Rezoning Transportation Analysis

Petition Number: 2021-092

From: Lakisha Hull, AICP, LEED AP BD+C

Date	Description
06-01-2021	First Review (KP)
08-23-2021	Second Review (KP)
10-22-2021	Third Review (KP)

SECTION E-E PEARL PARKWAY

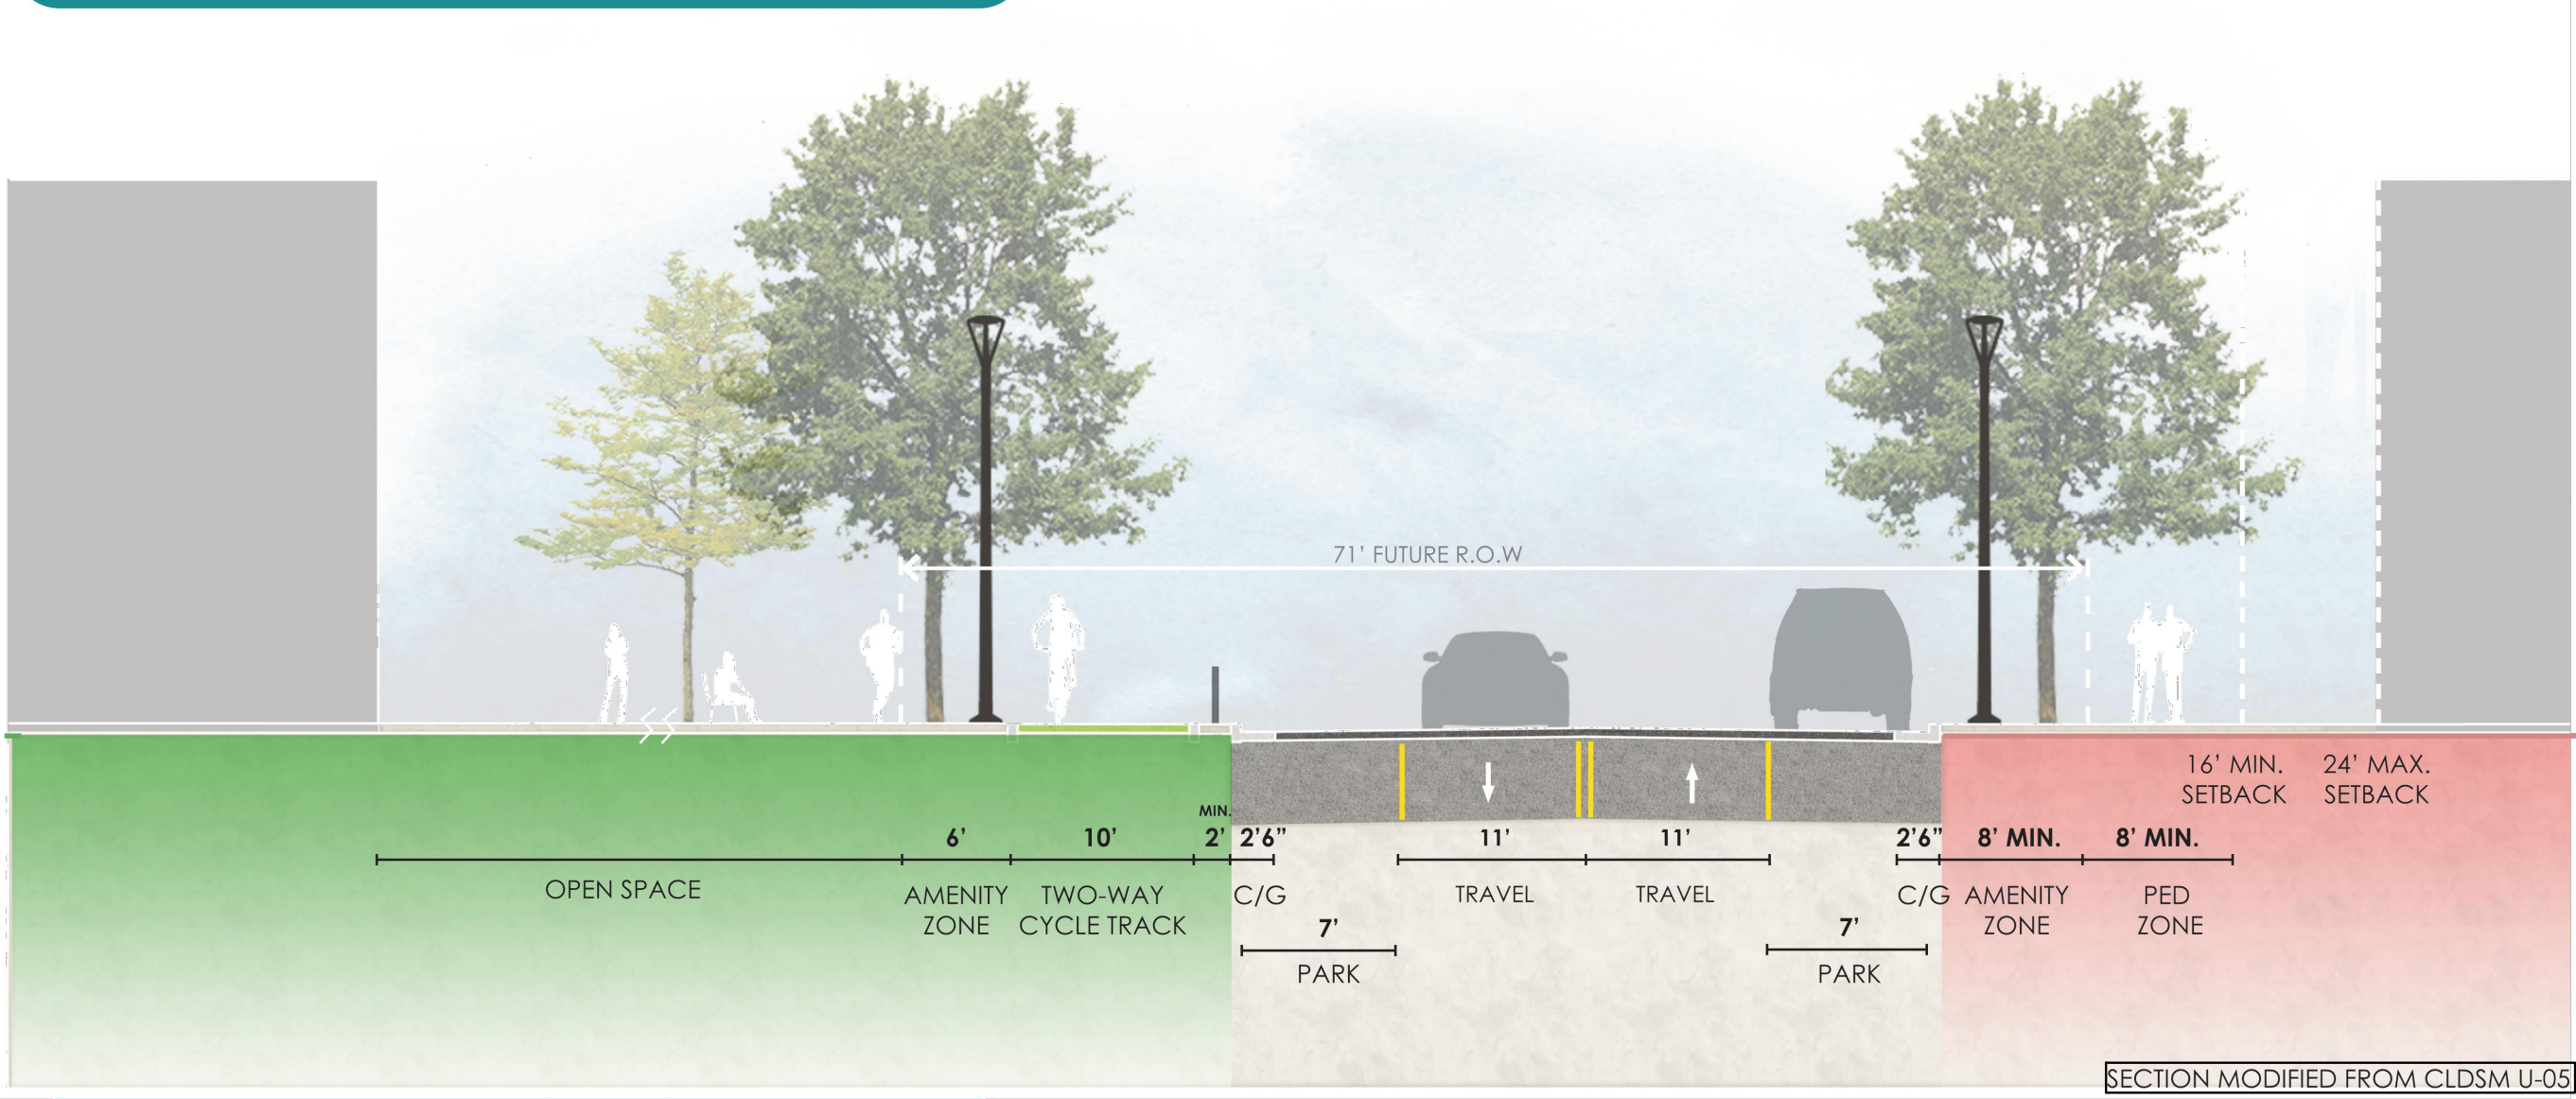
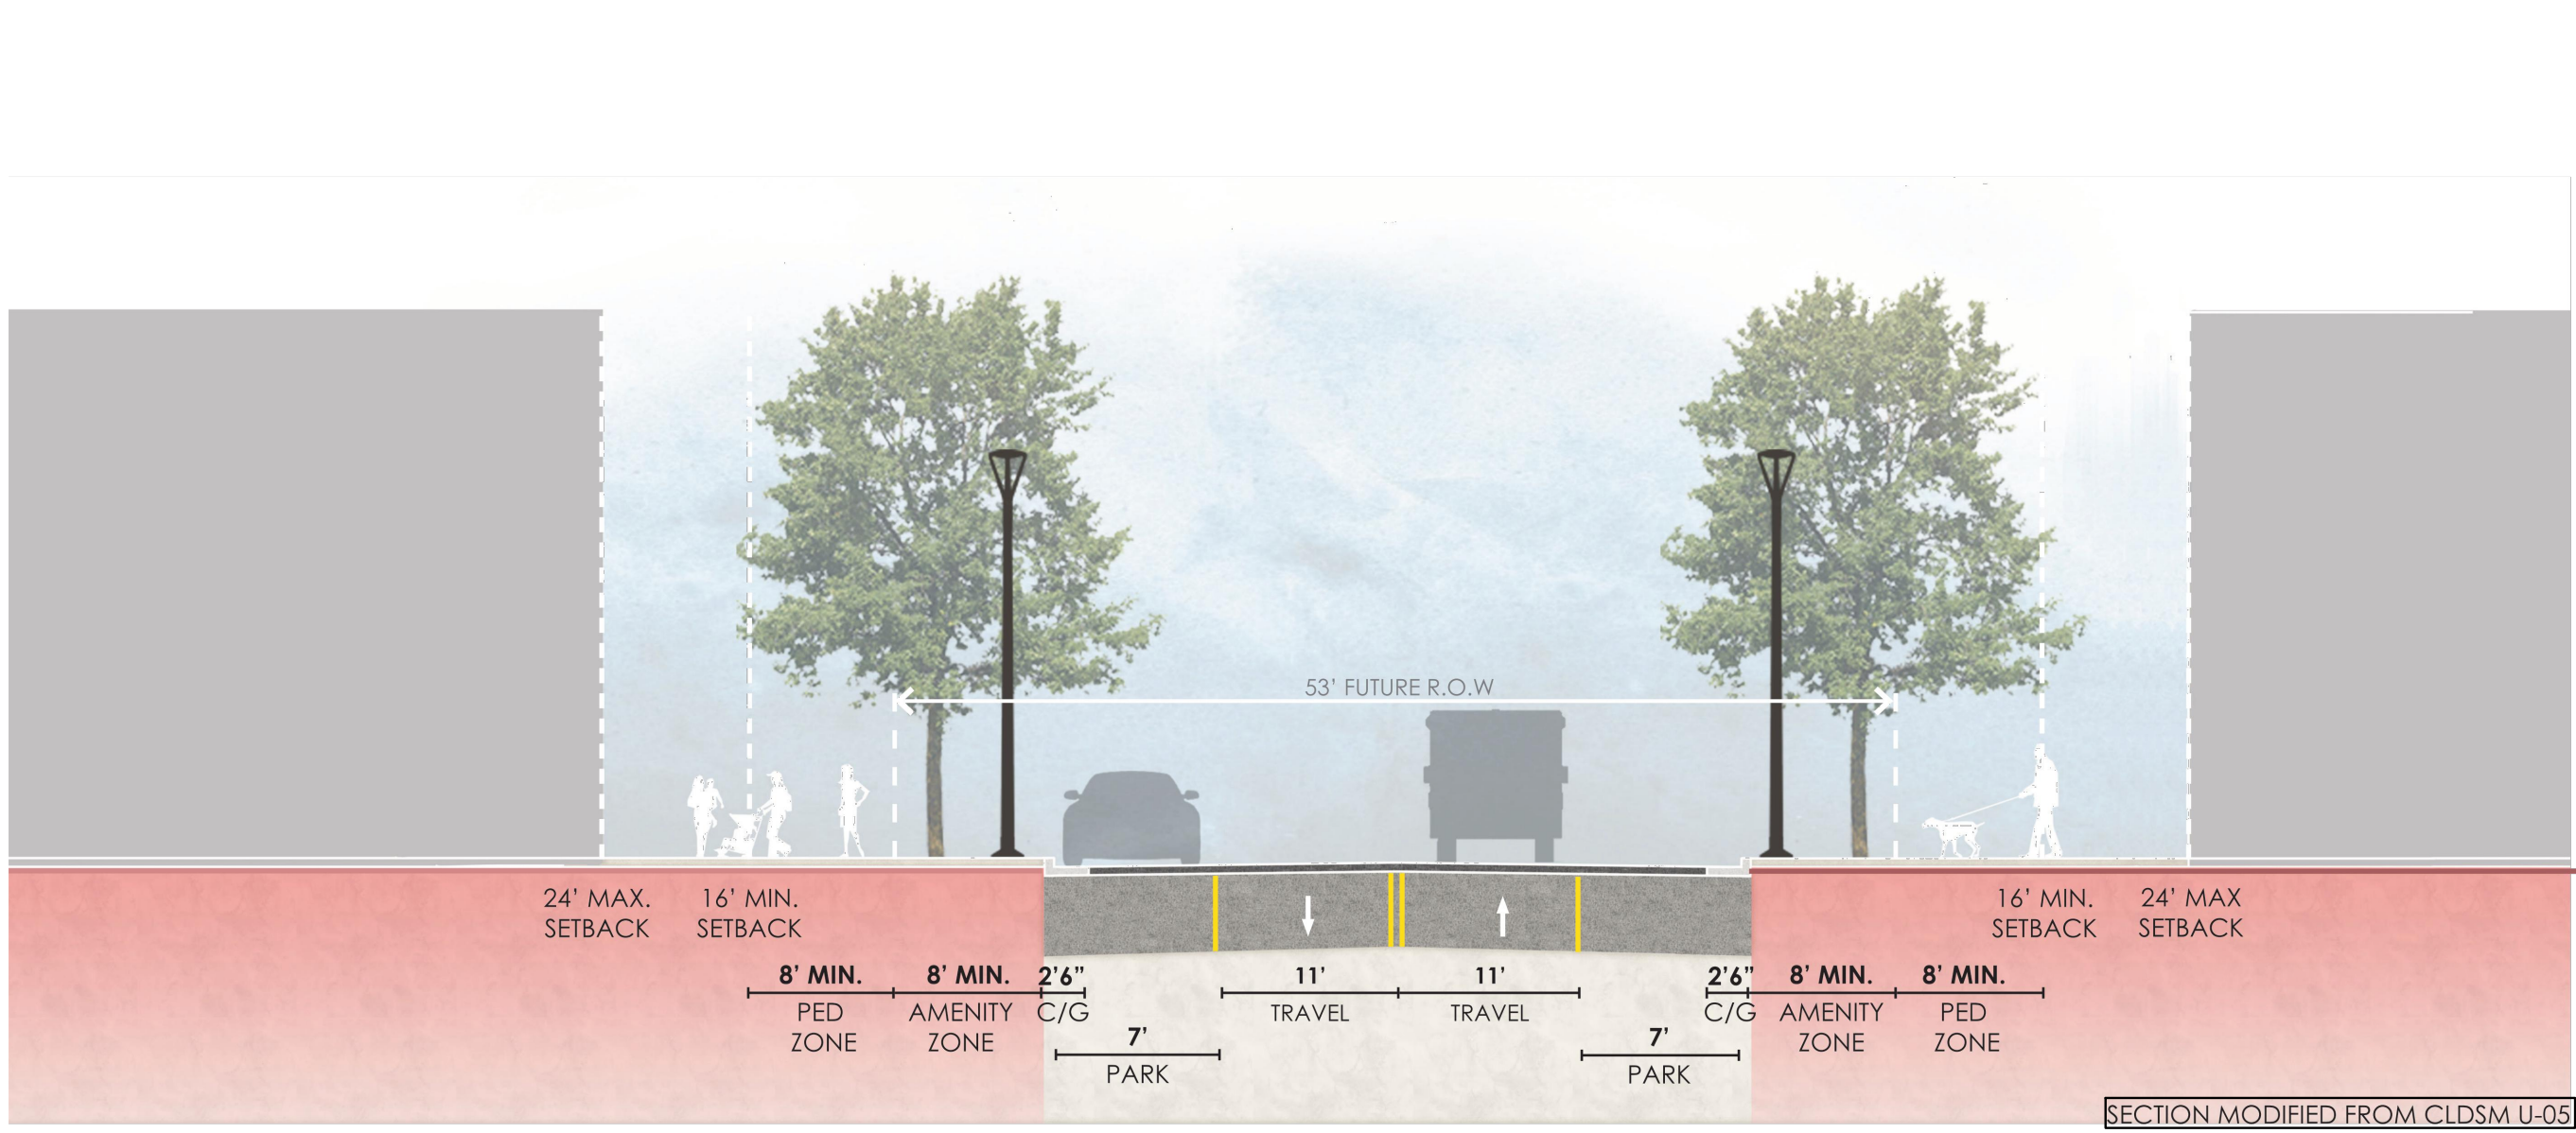
4. ~~Revise the Rezoning Sheet RZ-1.0 and RZ-1.1 by establishing a cross section associated with the proposed private street connecting McDowell Street to Baxter Street Extension. Include the cross section on Rezoning Sheet RZ-1.1.~~
